Vincent Cottage – North
Ford Road
Climping
Nr. Arundel
West Sussex
BN18 0BY

27th July 2017

Planning Application CM/20/17/PL

Concrete Moulding, Littlehampton
Environmental Noise Time History: 3
Location 3 - Yard

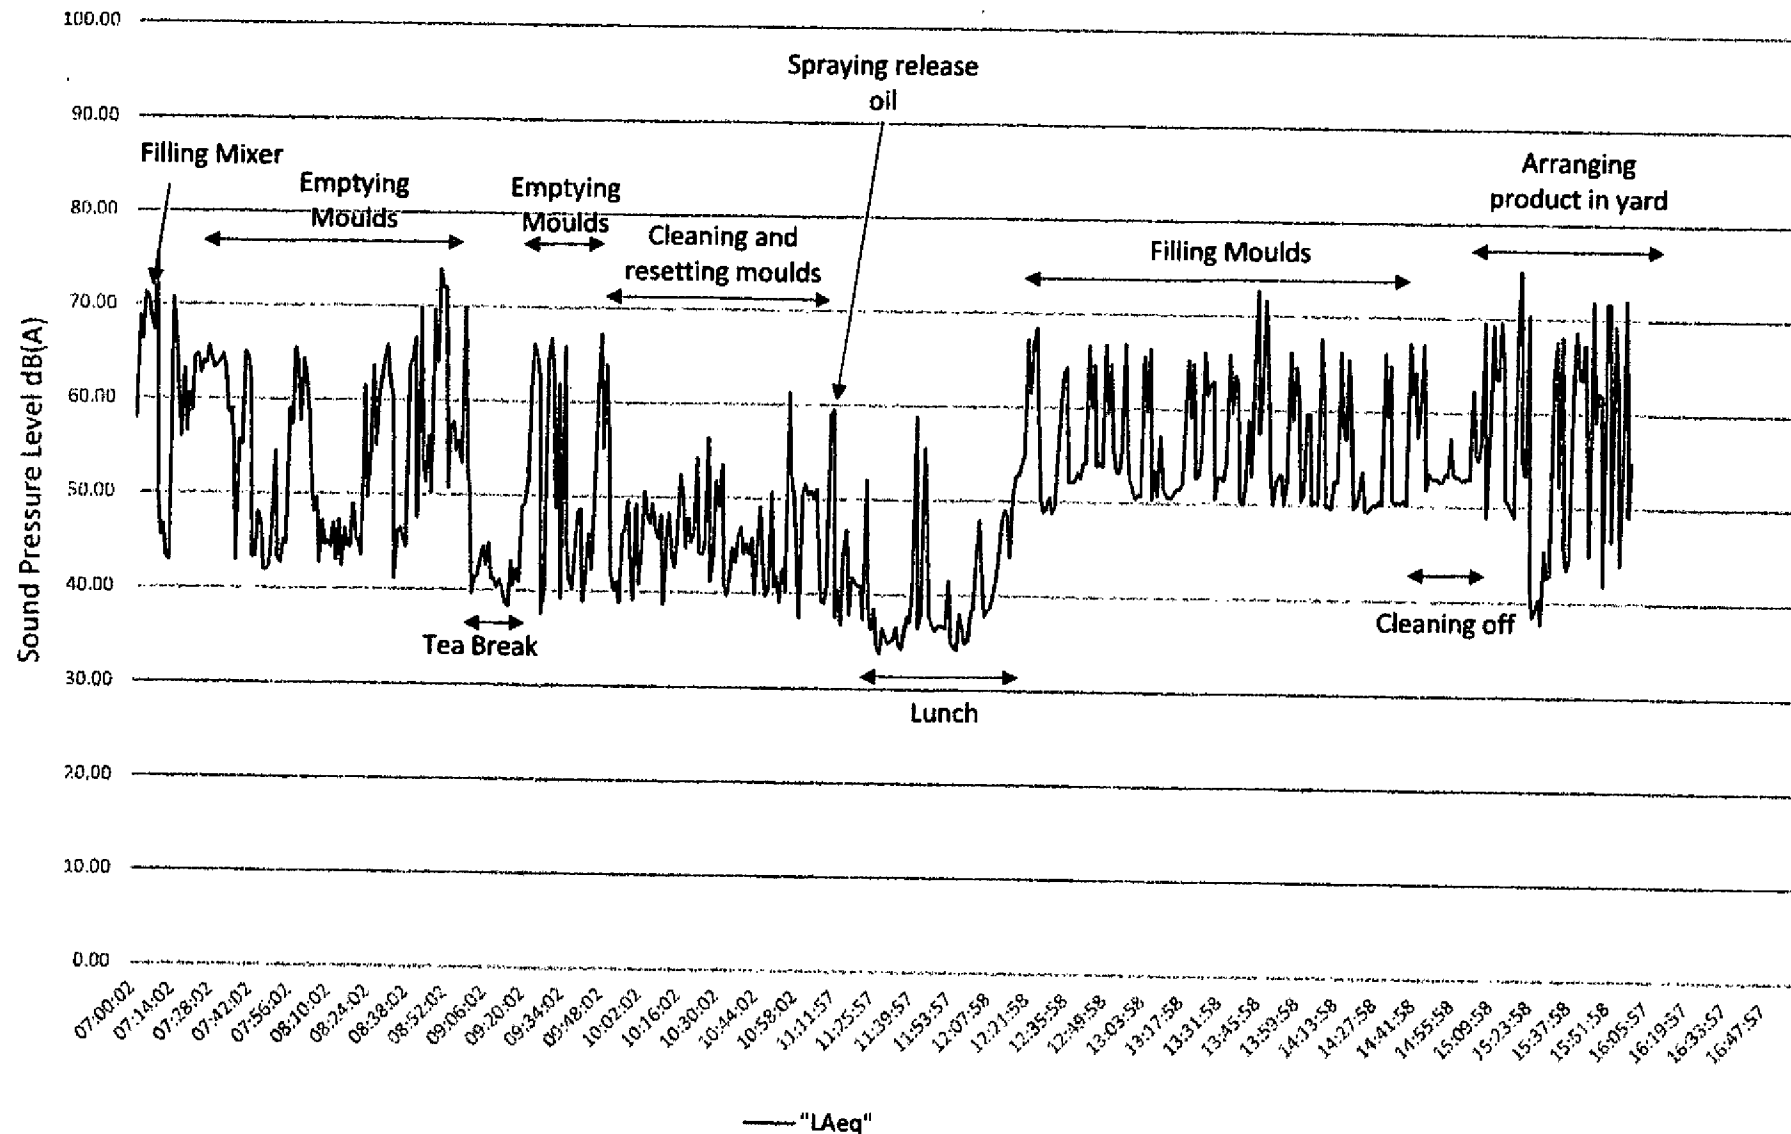
The reading taken by Venta Acoustics at Location 3-Yard would be directly comparable with those in my garden and would thereby fall into the nuisance category of being more than 10 DB (A) above the underlying level for 60-70% of the day. A slightly lower figure would be for the house but would still be a substantial increase in noise levels.

LAYOUT PLAN FOR
UNIT H21
RUDFORD INDUSTRIAL ESTATE
FORD
WEST SUSSEX

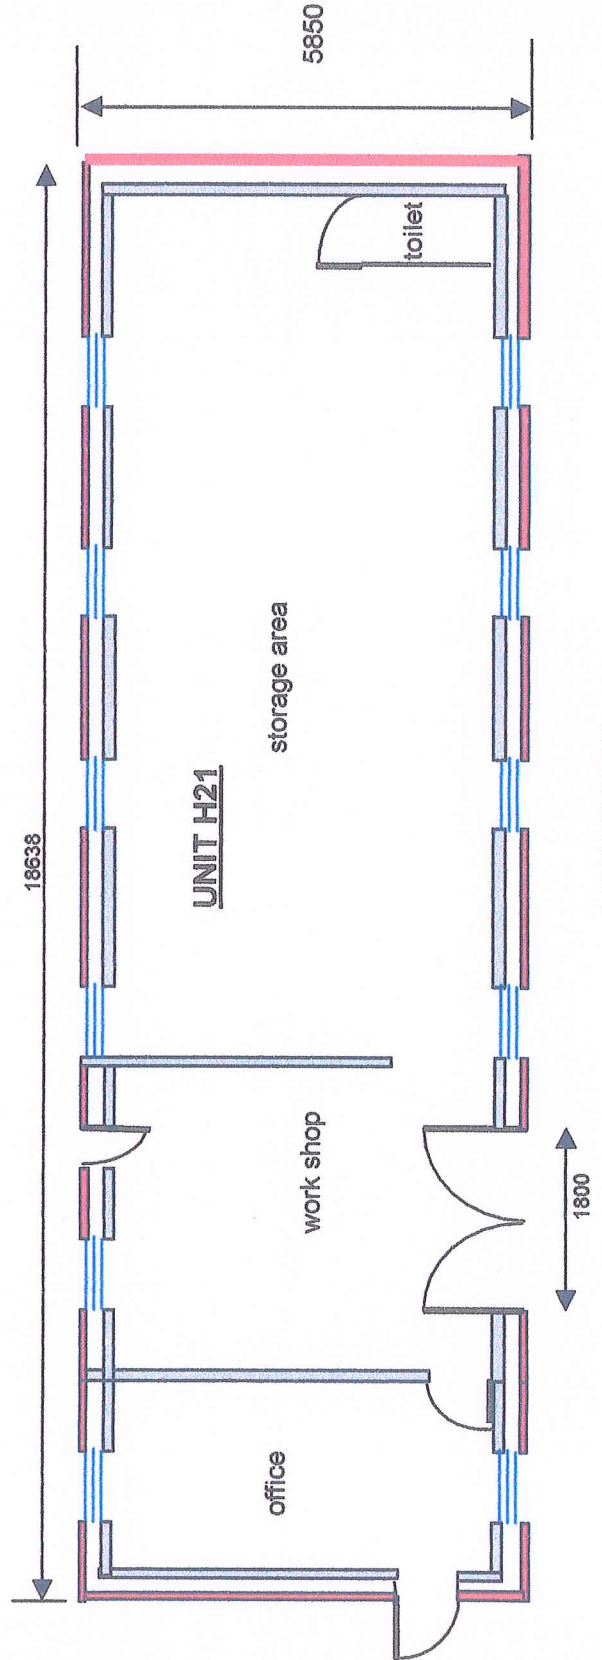
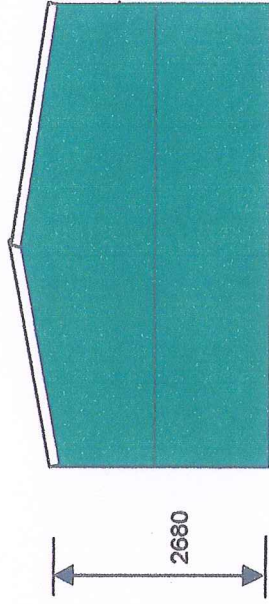
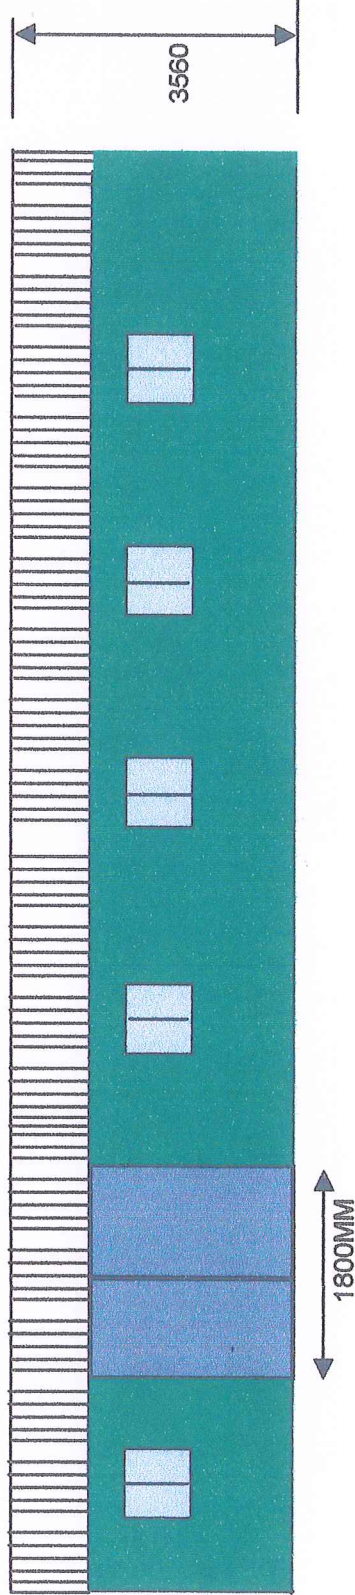
I note that no measures have been taken to attempt to mitigate noise from the site. For example acoustic fence panels of at least 2M height (which would assist in dust retention) or earth banks of sufficient height.

No fencing is shown in the Plan to shield operations from view in my garden. The only barrier being the largely bare trunks of overgrown leylandii.
